CITY OF ALBUQUERQUE

**Re: Desert Ridge Place Unit 3
Erosion and Sediment Control Plan
Engineer's Stamp Date 1-24-17 (C20E076)**

**DESERT RIDGE PLACE UNIT 3**  
**TEMPORARY EROSION CONTROL PLAN MAP**  
 PROJECT TITLE

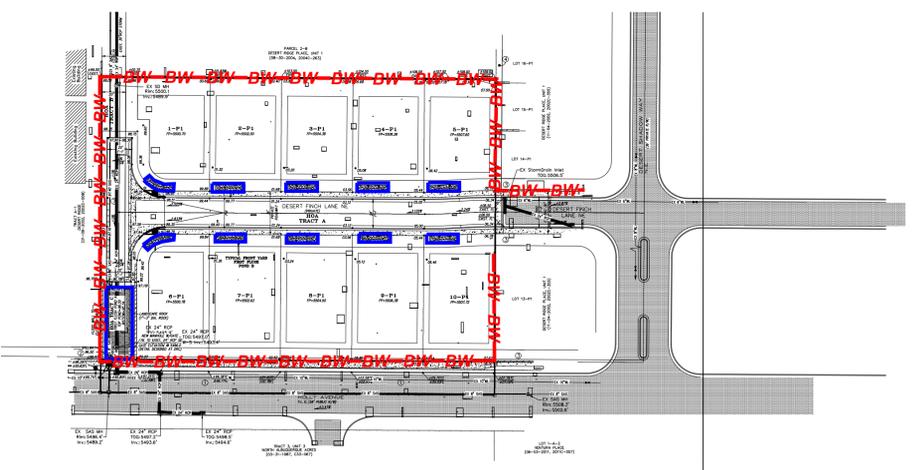
If a drainage inlet is required in the hammerhead, please submit a revised plan with BMPs for this work.
